MODIFICATION 23 TO SHOALHAVEN STARCHES EXPANSION PROJECT 06_0228.

ADDITIONAL INFORMATION REQUEST – ENVIRONMENTAL NOISE ASSESSMENT

Shoalhaven Starches – MP06_0228 Mod 23 – Gas Fired Co-generation Plant – EPA Comments

Figure 7. Near Field Noise Map of LM2500 Gas Turbine

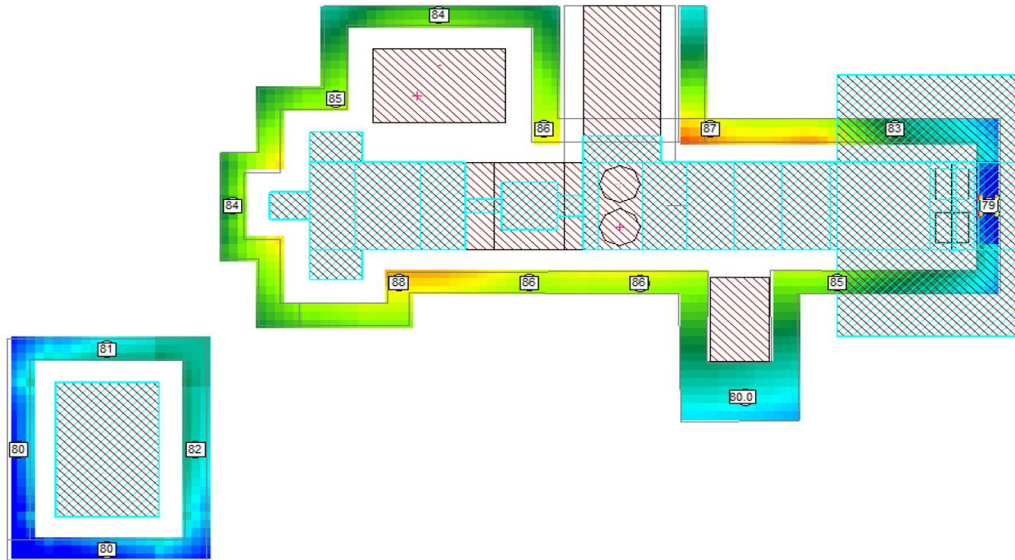
- To better understand the predicted noise levels at the receivers, the EPA would prefer that the NIA utilise noise modelling software, but as a minimum the EPA requires full and justified one-third octave spectral data for:
 - all sources proposed inside the buildings;
 - space averaged sound pressure levels including reverberation times;
 - the performance of the building fabric; and
 - the attenuation losses to the receiverswhich are then summed to provide an overall A weighted level.
- The one-third octave data should also be used to determine any low frequency or tonal characteristics. The fans and steam generators have potential to generate tonality. Intermittency from auxiliary equipment should also be assessed, as well as a statement on the potential for emergency pressure releases or similar.

An schedule of overall 'A' frequency weighted and octave band centre frequency near field sound pressure levels are shown in Table 3 of the Rev A ENA in Section 4. A noise map prepared and provided by GE representing the near field sound pressure levels around the LM2500 is shown in Figure 7. The noise map shown in Figure 7 was reportedly produced by GE using *CadnaA* acoustical modelling software and a screen shot of that model is shown in Figure 8.

- d. See response to item b above for details of acoustical modelling as well Figures 7 and 8 in the Rev A for the noise data provided based on GE's noise model,

Figure 13. One-Third Octave Band Spectrum Boiler Fan

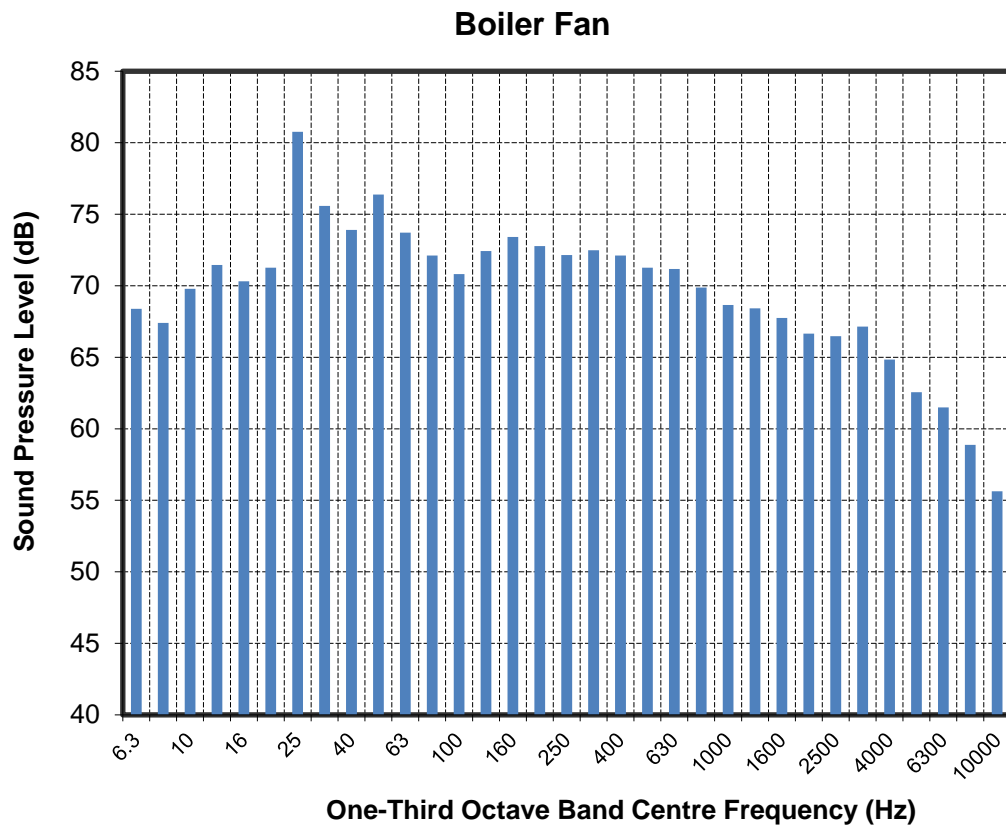
In the EPA's experience, co-generation plants have demonstrated to be difficult to attenuate the annoying characteristics. These types of plants can generate significant low frequency noise and other characteristics such as tonality and intermittency. The NIA indicates from a basic assessment in Section 4.2.3 that there is potential for low frequency noise from the proposed Shoalhaven Starches co-generation plant and the potential for noise limits to be exceeded if the plant is approved and built.

The assessment of modifying factors should be conducted in accordance with Fact Sheet C of the NPfI. The assessment must be quantitative and any calculations relied on to determine the presence (or not) of modifying factors must be included in the report. An example method for determining low frequency noise was published in Acoustics Australia and can be found here: <https://doi.org/10.1007/s40857-020-00199-x>

For the purpose of determining the potential for tonality from the HRSG equipment, consideration was given to one-third octave band spectral measurements of existing boiler equipment at the Shoalhaven Starches facility. This is provided in Figures 13 and 14 in Section of the Rev A ENA. Existing boiler equipment, as measured, does not exhibit tonal characteristics.
